Norwich to Tilbury

Volume 9: Change Application

Document: 9.12 Proposed Change Application 2: Addendum to
Environmental Statement - Change Request 2 (Little Bromley) (CA2)

March 2026

Scale	Sheet Size	Sheet	Issue
1:2,500	A0	SHEET 15 OF 18	CA2

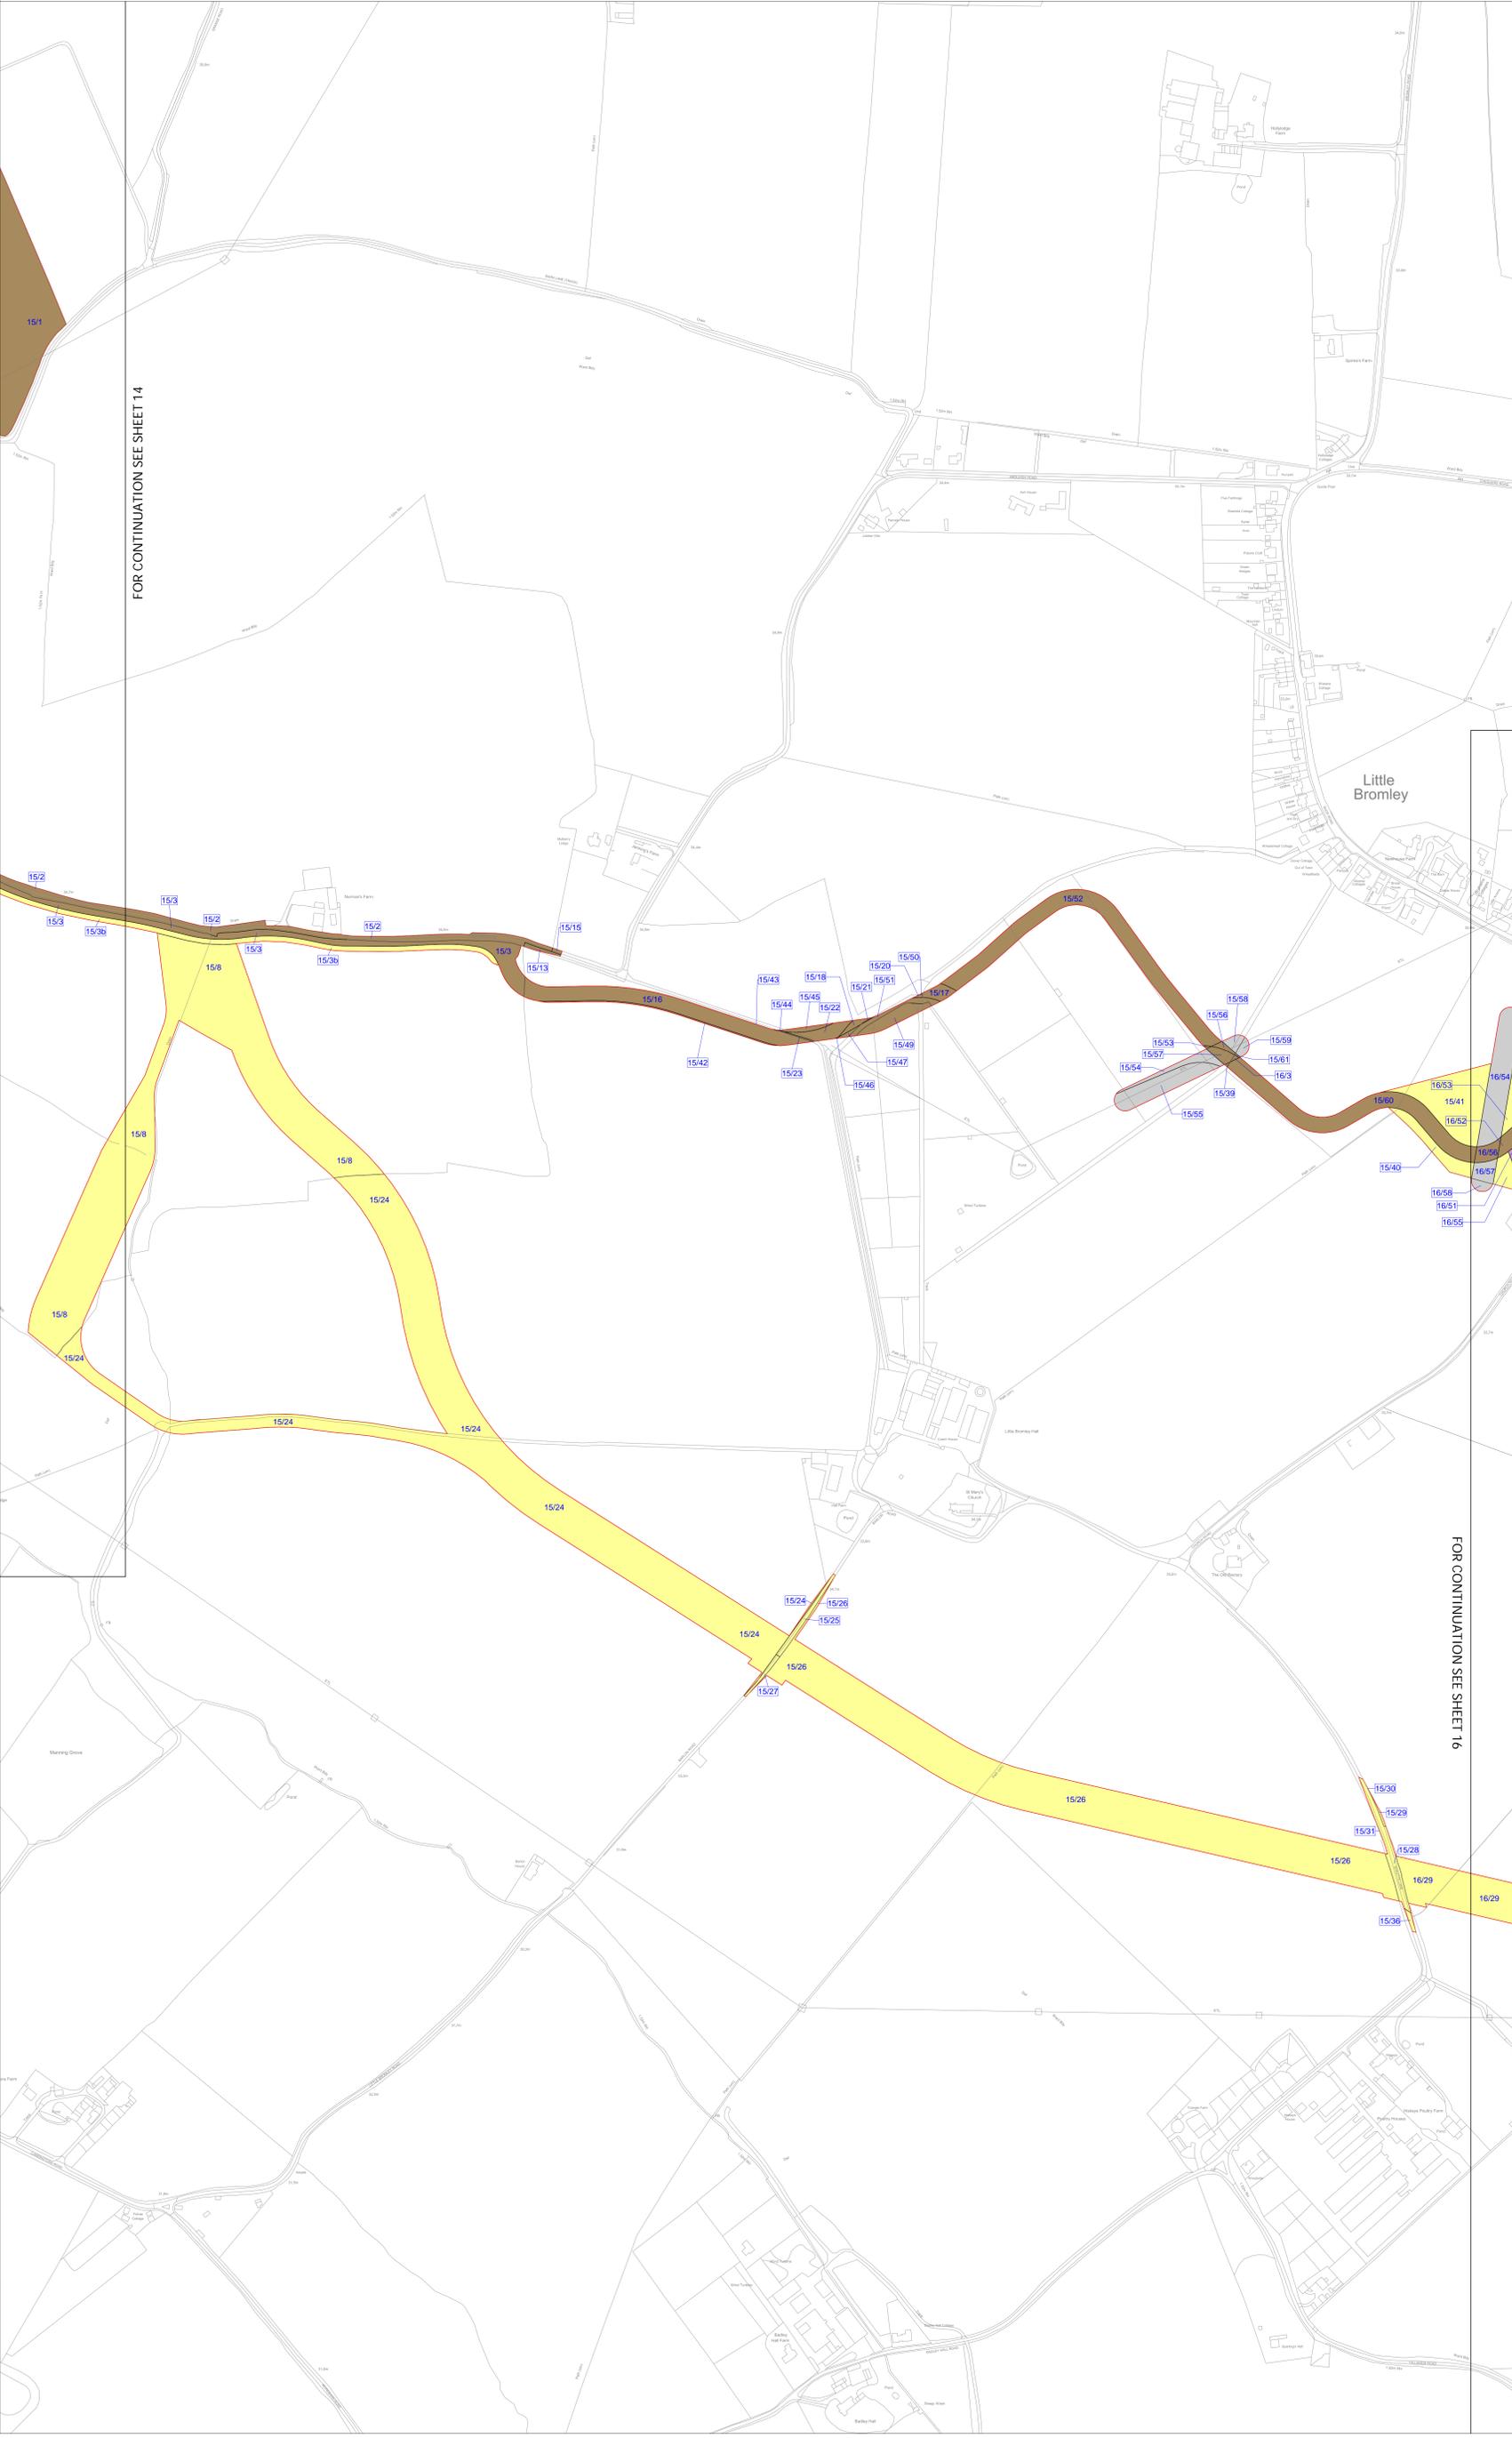
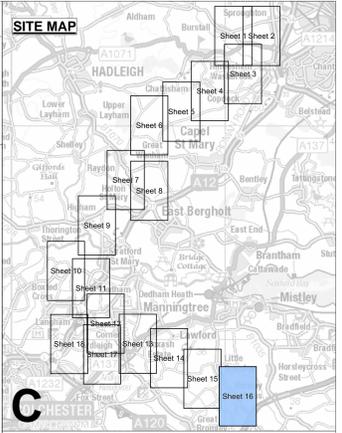
- 1.3.3 The proposed design change would involve two modifications to the Proposed Route:
- First, a section of the Proposed Route nearest to Bentley Road is realigned to the south, for the permanent access relating to Abnormal Indivisible Loads (AILs) during the operational phase of the Project. The need for a permanent AIL route is to ensure supply standards for the connection are met in the future (by allowing replacement of any component at short notice).

- Second, to the northwest of the first modification, the Proposed Route for both construction and operational vehicles is changed to generally follow the alignment of the Proposed Route presented at statutory consultation between 10 April and 26 July 2024.

- 1.3.5 Additionally, precautionary amendments to existing wood pole supported infrastructure would be accommodated as part of the works e.g. uplifting them.
- 1.3.6 Assumptions on the construction and operation of haul roads can be found in **6.4 Environmental Statement Chapter 4 - Project Description [APP-130]**.
- 1.3.7 The proposed change is shown on the figures in **Appendix A of Proposed Change Application 2: Overview Report – Change Request 2 (Little Bromley) [document reference 9.6]** and plans within **Proposed Change Application 2: Book of Plans – Change Request 2 (Little Bromley) [document reference 9.14]**.
